9<sup>th</sup> December, 2010

**Re: Development Application MP10\_0160 (Scottish Hospital, 2 Cooper St, Paddington)**

Option 1 | Proposed Stand of Advanced *Waterhousia floribunda*

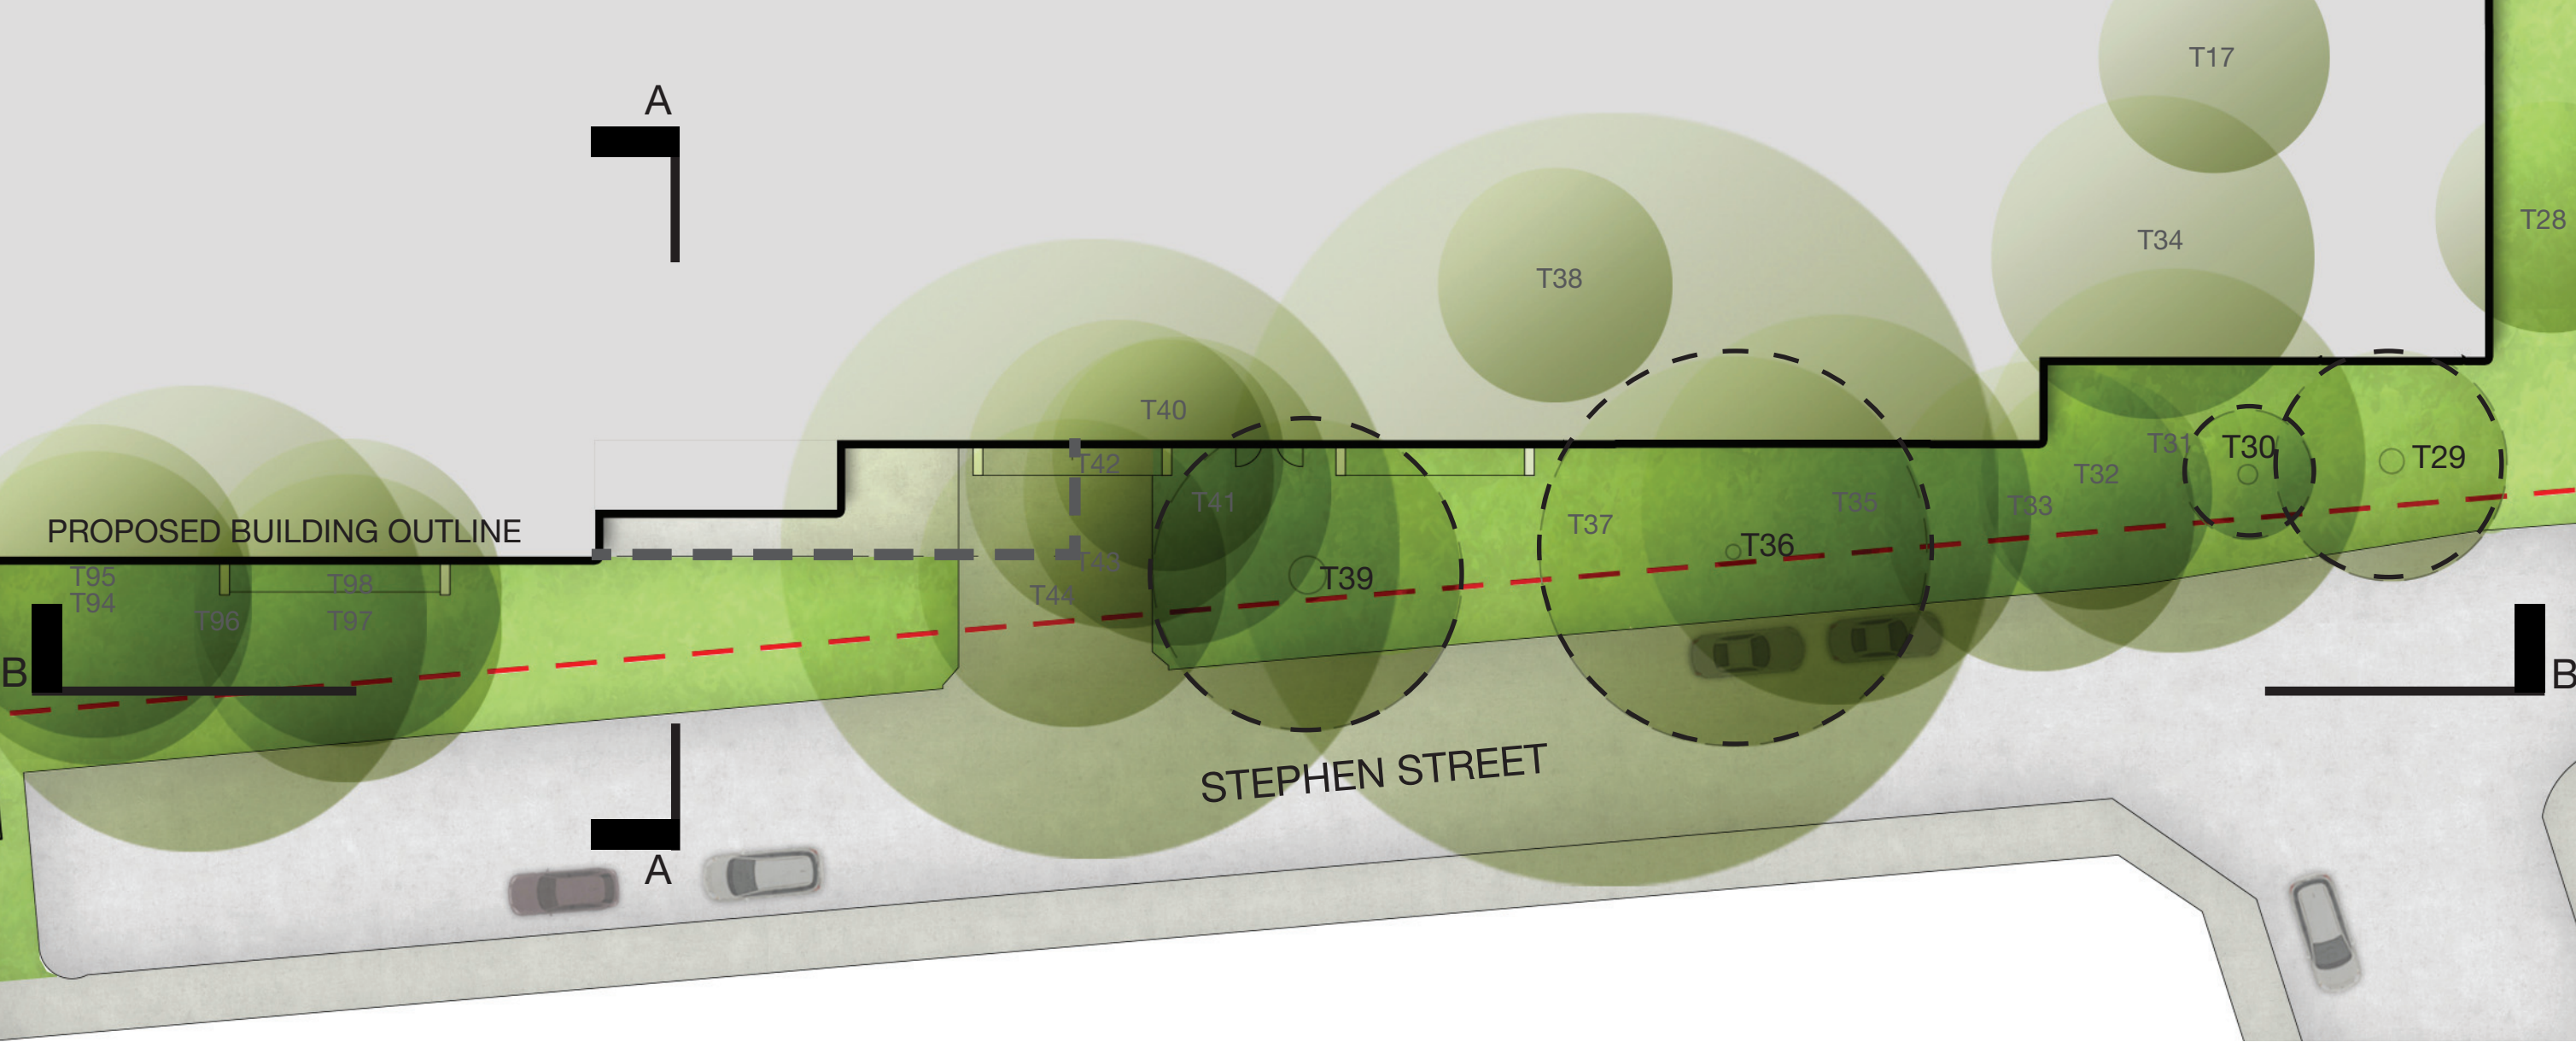
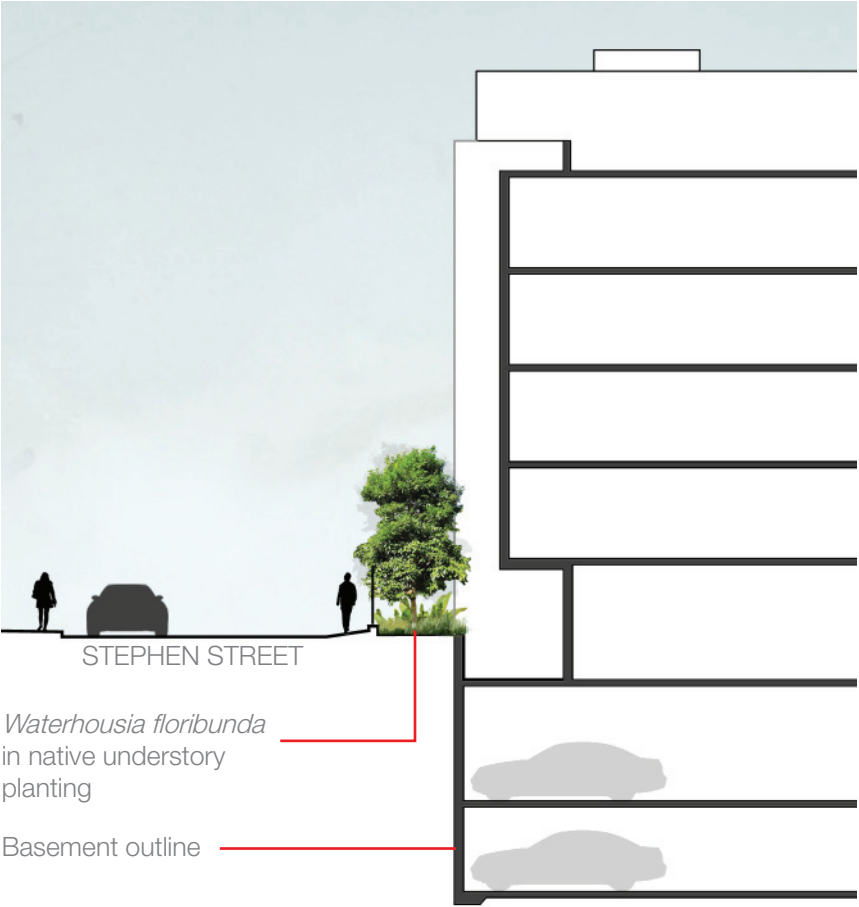
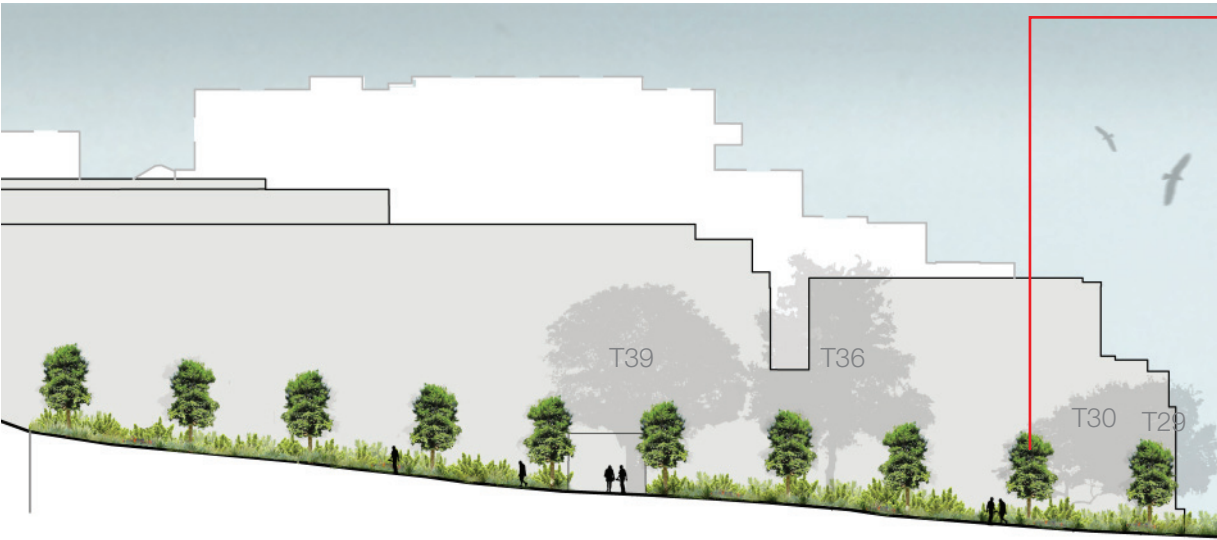
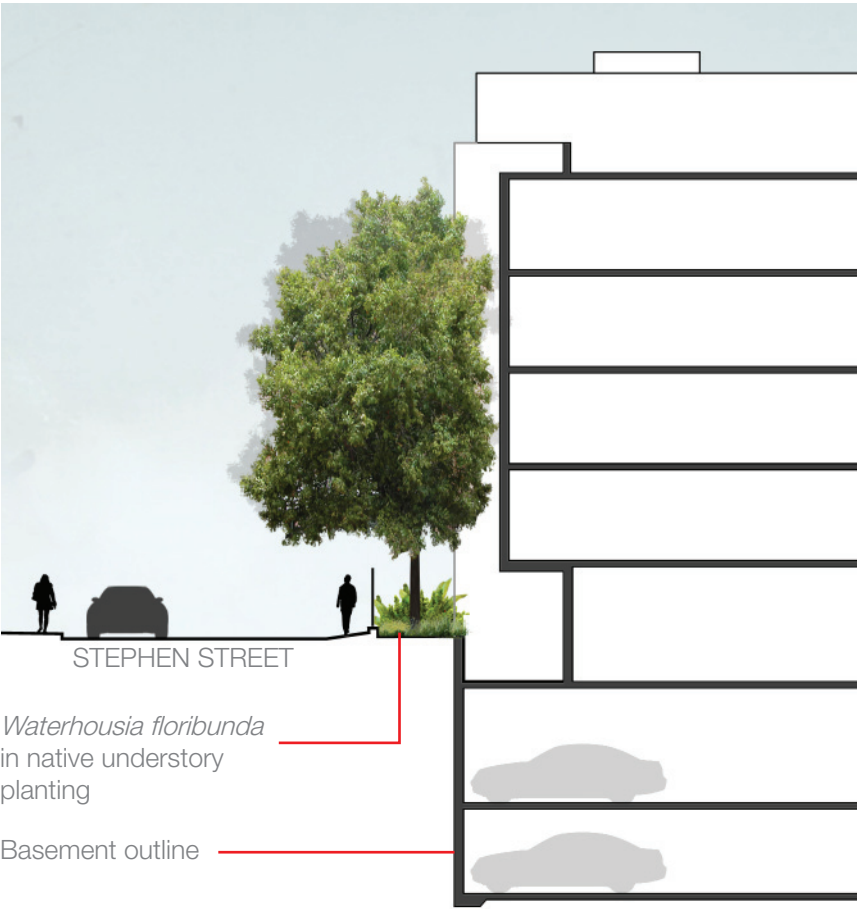
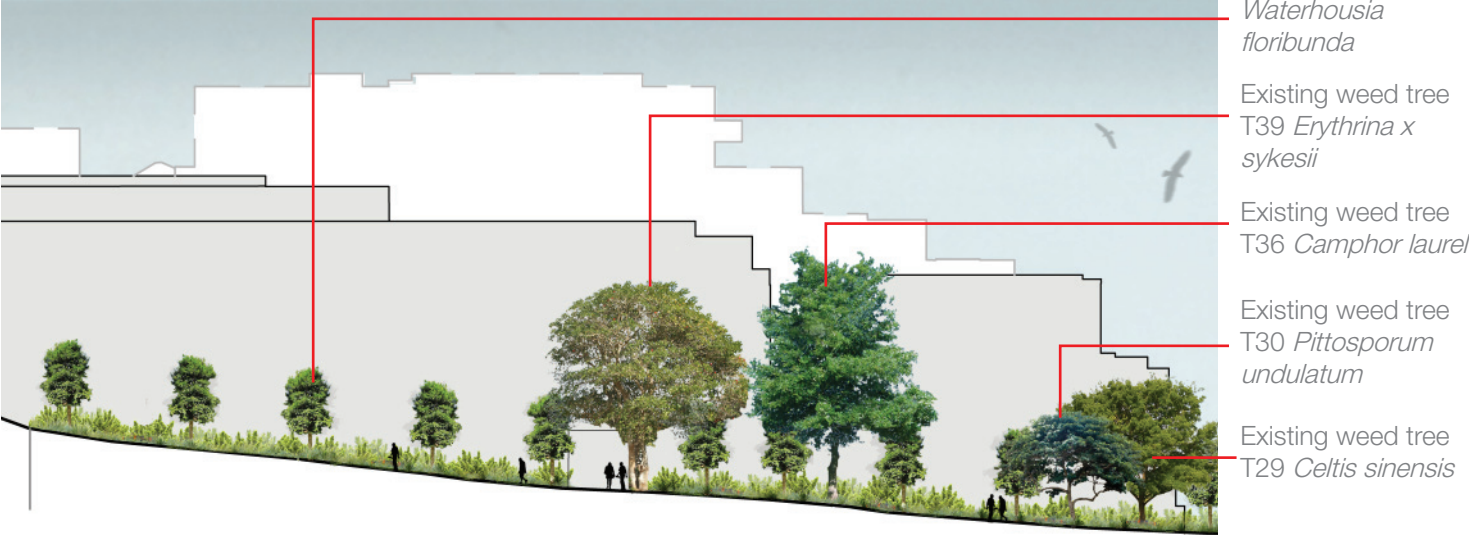
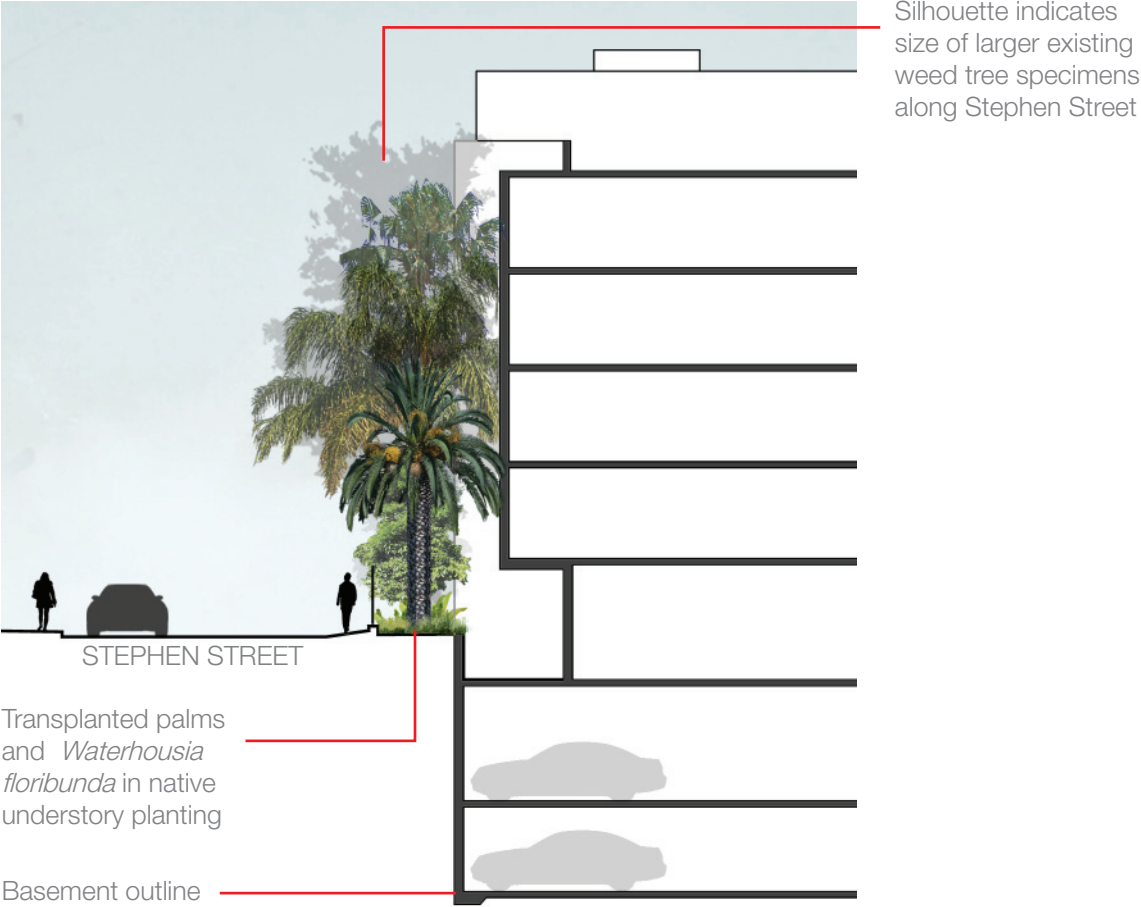
- The removal of all the trees directly opposite 40 Stephen St is not required. Several of these trees are well established and I'm informed some of them should be protected under regulations by Woollahara Council as they are greater than 10m in height. The Arborist Advice Survey has given these trees a 'Retention Value B Rating' and it seems these trees are being removed against the residents' request, purely because it is more convenient for the developer. The Camphor Laurel and Brushbox trees opposite 40 Stephen St should be kept.

- The new trees to be planted on Stephen St are inadequate and will fail to grow to significant size for many years (if ever). There appears to be inadequate space for the trees to grow and the same species of tree have failed to grow well in the Dillon St Reserve. I believe the development drawings are very misleading and that even after 10 years of growth the trees will be approximately 50-80% smaller than the drawings and models in the development proposal suggest.
